Anita Gardner
Principal Planning Officer,
Directorate of Place

CM/64/19/PL and CM/16/20/PL

Drg No: 190725-HT-F1-FP	Rev: A
-------------------------	--------

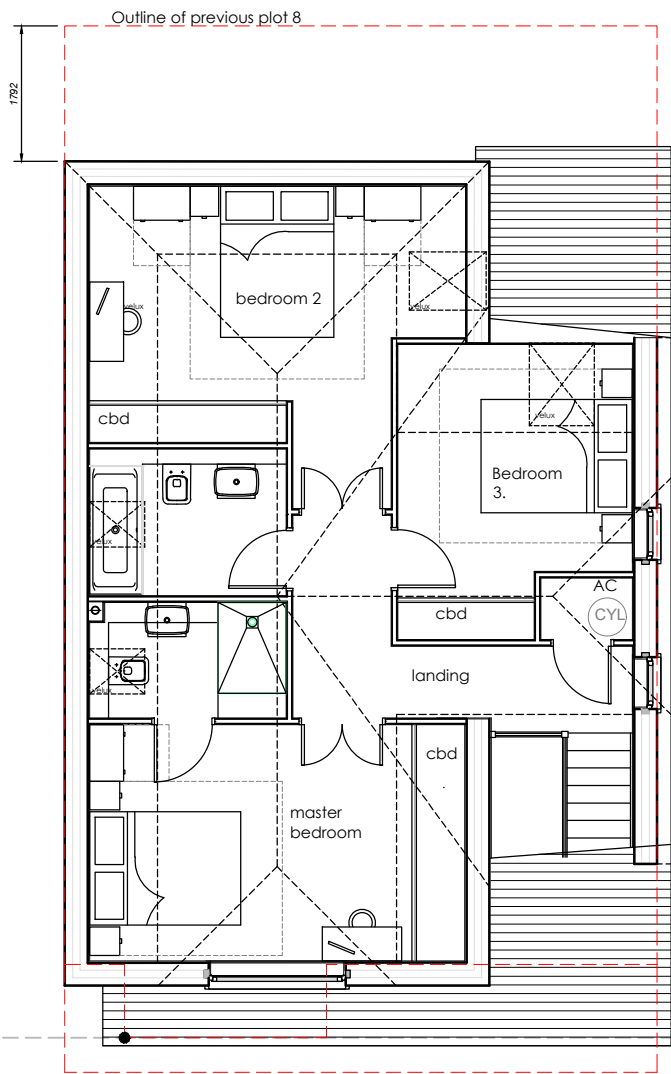
Please see an extract of a representation I have received . Can you provide comment on the differences between the plans and why it seems there is a difference in the approved drawings when they are imposed over the proposed by him?

Below is a photo of the plans of plot 8, CM/64/19/PL and plot 8, CM/16/20/PL. I have traced the outline of CM/64/19/PL on to CM/16/20/PL. Both plans were drawn to the same scale as the widths of the two designs are identical and both were printed out on the same printer. You will notice that my red dotted outline appears significantly different to the one supplied by the applicant – see below. Not only does the roof appear higher but also longer. This leads me to believe that either the original plans have been altered or the architect has made a mistake drawing in the red dotted outline on the new plans.

The length of the house is as shown, however the positioning of the plot is relative to the parking bay in front, consequently we have tried to move new the plot as far north as we can so as to limit the impact at the rear. To locate the plots, the corner of the window bay is the same in both versions (as per the plans I sent you recently) but the posts and overhangs are not the same in both schemes , hence the slight difference in appearance/length.

Rear elevation

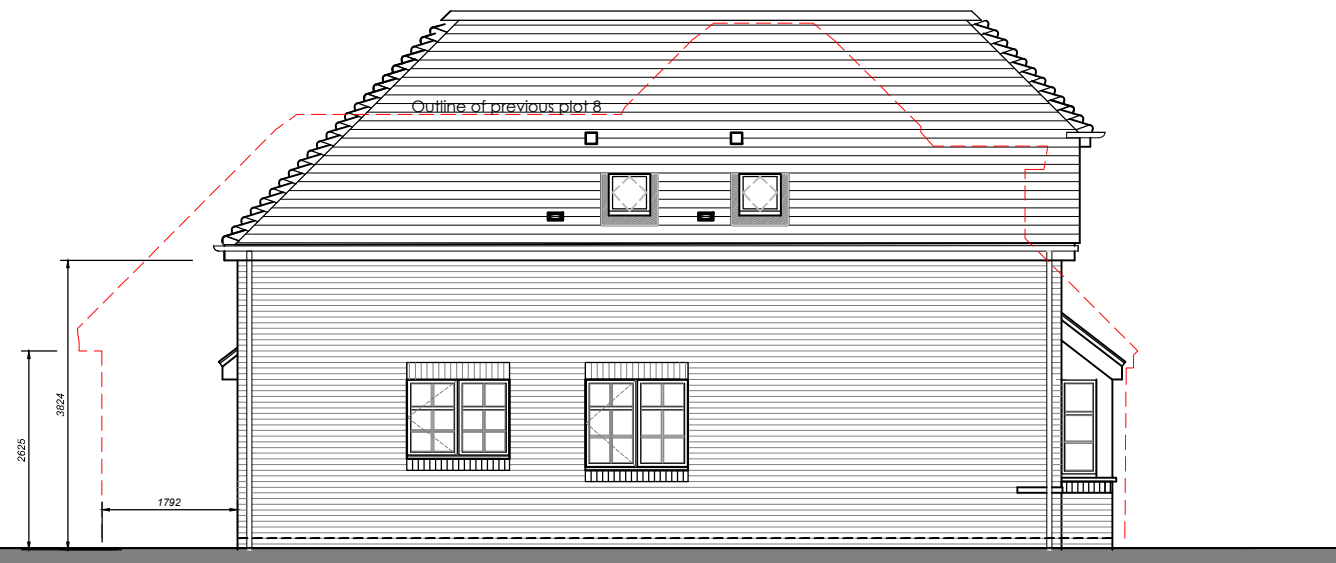
Can you let me have a revised copy of the comparison plan originally submitted in PDF form so that I can add it to the submitted substitute plans? I think comparing the rear elevation proposed with the outline of what is approved at the rear is a clearer reference than already submitted.

In respect of the dotted roof/ridge lines it appears the representation is shows a much lower roof line which is in fact the rear of the previous scheme, whereas we have shown the front of the outline of the previous scheme. For clarity, I am attaching an image showing the both the front roof and the rear roof superimposed over the rear elevation.
